## **Suffolk County Council (20041323)**

Post-Hearing Submission for the Fourth Issue Specific Hearing (ISH4) on Various Environmental Matters, including Biodiversity, the Historic Environment, Landscape

## **Bramford to Twinstead (EN020002)**

16 November 2023

ELEVATION - B  
 SCALE 1:150

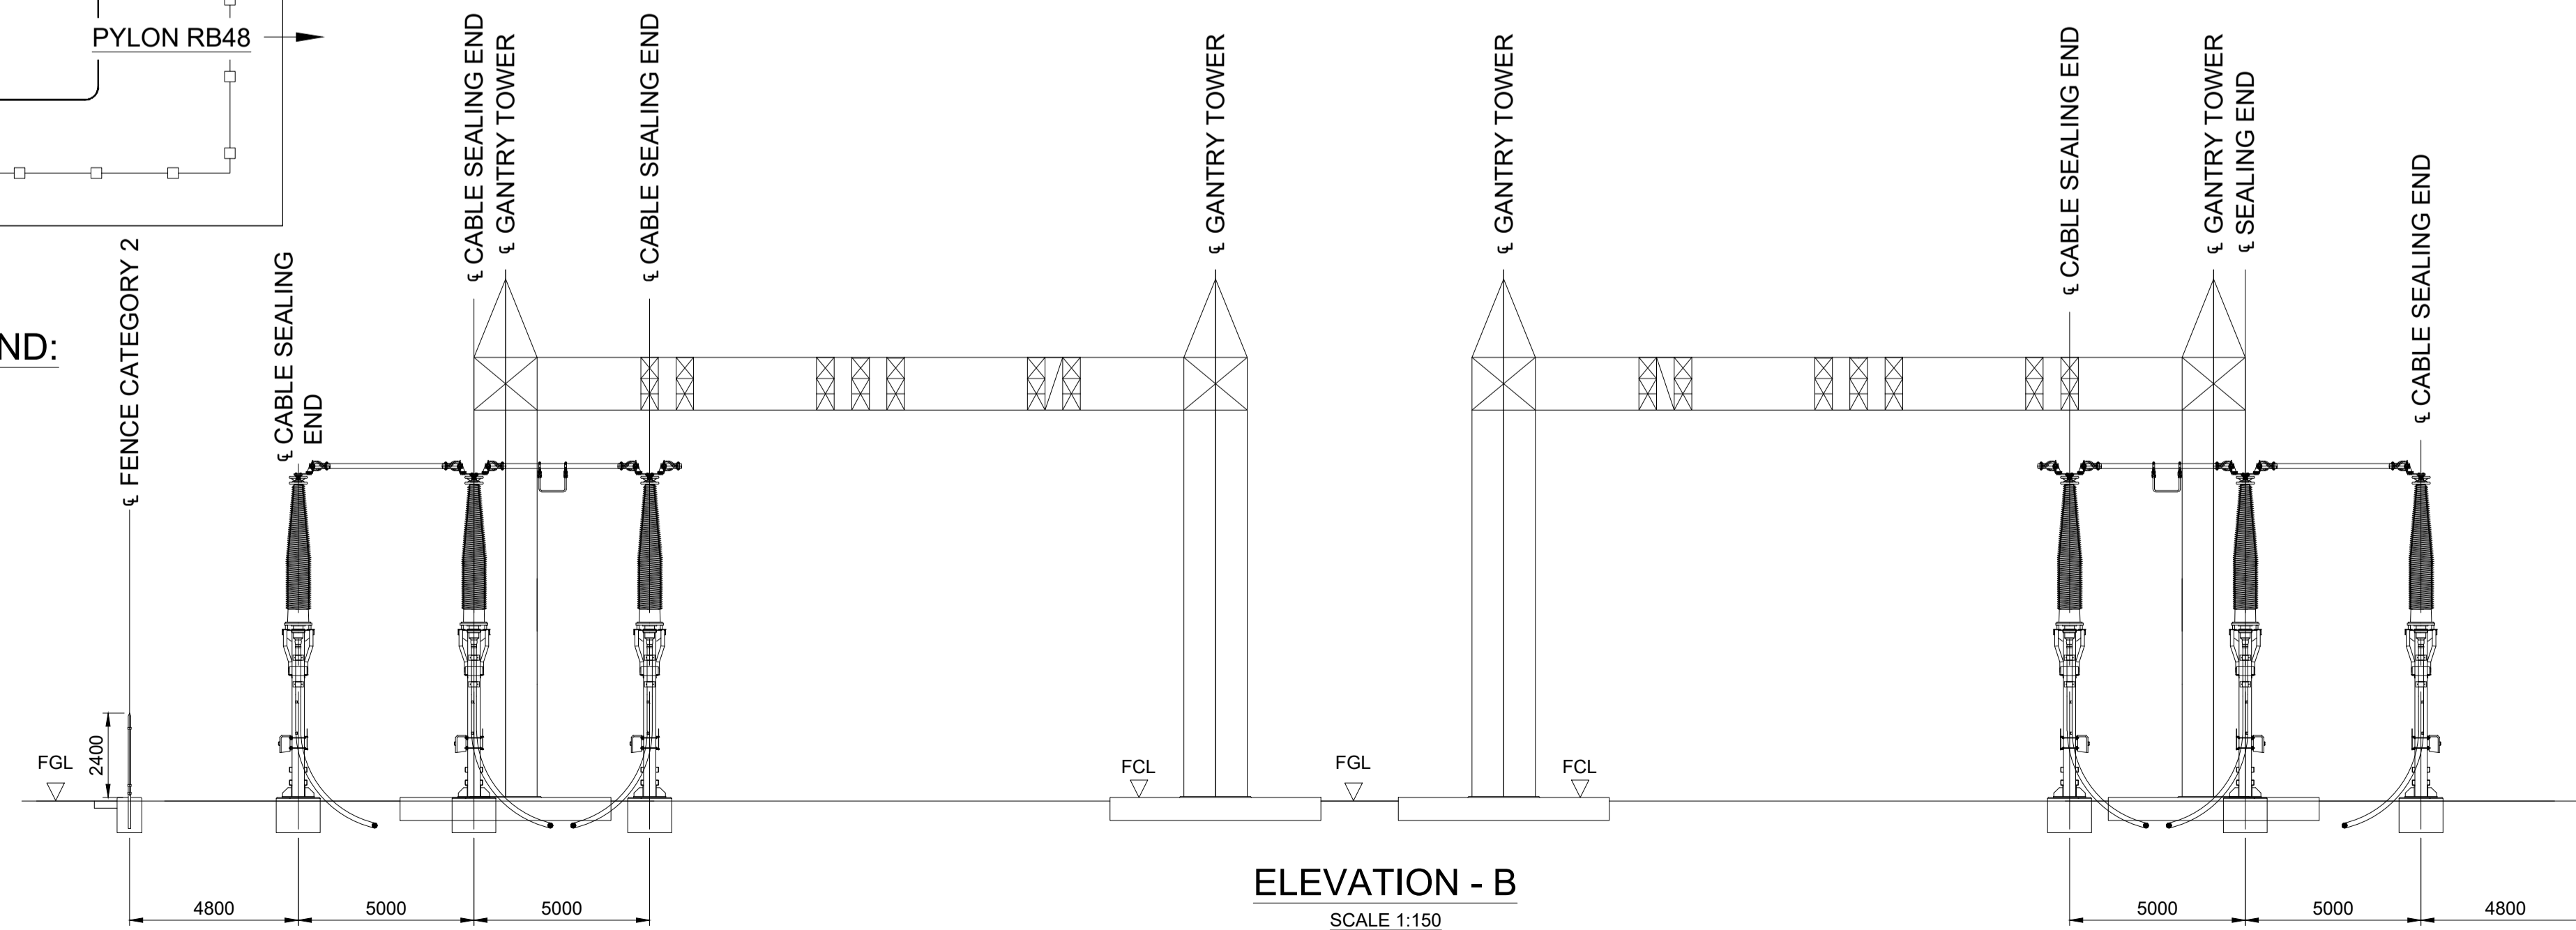
<b>PRoW network on the edge of Wickham St Paul</b>	
	<p>SCC (Landscape) is broadly content with the overall number and representativeness of the viewpoints as part of the ES. However, the Council agrees with Essex County Council and Braintree District Council that there is a lack of viewpoints in some areas, for example around the proposed haul road, and that there are a lack of viewpoints from PRoW nearer to the scheme, for example, regarding the cable sealing end compound at Workhouse Green (Stour Valley East), as identified by the Councils.</p>
<b>5.7 Sufficiency of visual mitigation for the cable sealing end compounds</b>	
	<p>SCC (Landscape) considers the visual mitigation for the cable end sealing compounds insufficient for Dedham Vale West Cable Sealing End Compound at Leavenheath and Stour Valley West Cable Sealing End Compound at Alphamstone (Essex) (LIR <b>[REP1-045]</b>, paragraphs 6.141 and 6.145).</p> <p><i>Dedham Vale West Cable Sealing End Compound at Leavenheath</i></p> <p>SCC (Landscape) welcomes the strategic positioning of the Cable Sealing End Compound north-west of the existing tree group, as this will provide useful screening. However, SCC considers that there should be continuous roadside hedge planting on the north-eastern side of the B1068 from the boundary of the apple tree farm in the east to the access track. Instead of relying on regeneration of coppiced hedges directly adjacent to the road, the hedgerow should be set back sufficiently from the road to design in the requirements of the visibility splay (i.e., north of the ditch). The hedge should have a return into the access track. The hedge to the eastern side of the access track should continue all the way to the northern end of the access track and should include hedgerow trees. The proposed planting along the A134 may (regeneration of coppiced hedge) may need to be re-assessed and contingencies made available for additional planting, should the regeneration not be successful.</p> <p><i>Stour Valley West Cable Sealing End Compound (Essex)</i></p> <p>SCC defers to the recommendation for mitigation by Braintree and Essex County Councils for additional mitigation on this site but considers that the existing roadside vegetation along the north-eastern side of the lane between Pebmarsh Road and Mabb’s Corner should be strengthened, and the existing hedges managed in such a way that they afford better screening of the cable sealing end compound. While tree planting over the cables is not possible, options for hedge planting on the southern side of the compound should be explored to create several layers of</p>

<p>mitigative planting to filter the views from the south.</p> <p>SCC (Landscape) further considers that it will be essential for the remaining cable sealing end compounds to retain the existing vegetation, ensure that that root zones are adequately protected and that landscape proposals will be fine-tuned at the detailed design stage and augmented, where required.</p> <p>At Dedham Vale East Cable Sealing End Compound at Polstead Heath the proposed hedgerow reinforcement along Millwood Road will be essential, including achieving a sufficient height of the hedge so that views form Millwood Road area screened.</p>	
<p><b>5.8 Sufficiency and security of landscape and visual mitigation and compensation planting generally</b></p>		
	<p>SCC (Landscape) considers that the proposals for landscape and visual mitigation and compensation planting generally is insufficient and insufficiently secure (reliant on Third Party agreements) (LIR <b>[REP1-045]</b>, paragraphs 6.16, 6.113, 6.117).</p> <p>SCC (Landscape) considers that the Landscape and Ecological Management Plan does not sufficiently secure re-instatement and mitigation planting. Not only is the LEMP in its current form not detailed enough to be considered the final LEMP, but it also contains fundamental flaws, which would make it unacceptable even as an Outline LEMP. Elements that are considered unacceptable include the planting schedules (species selection and percentages in the mix, sizes of tree stock, uniformity across the scheme), provisions for aftercare, such as timing to hand responsibility back to landowners, aftercare period for trees, aftercare prescriptions and periods for natural regeneration of woodland.</p> <p>SCC (Landscape) considers it would be preferable to agree a revised Outline LEMP, with detailed LEMPs being provided with the planting proposals for each section at post consent stage. SCC (Landscape) will provide a full review (tracked-change version) of the D3 LEMP <b>[REP3-034]</b> for Deadline 5.</p>
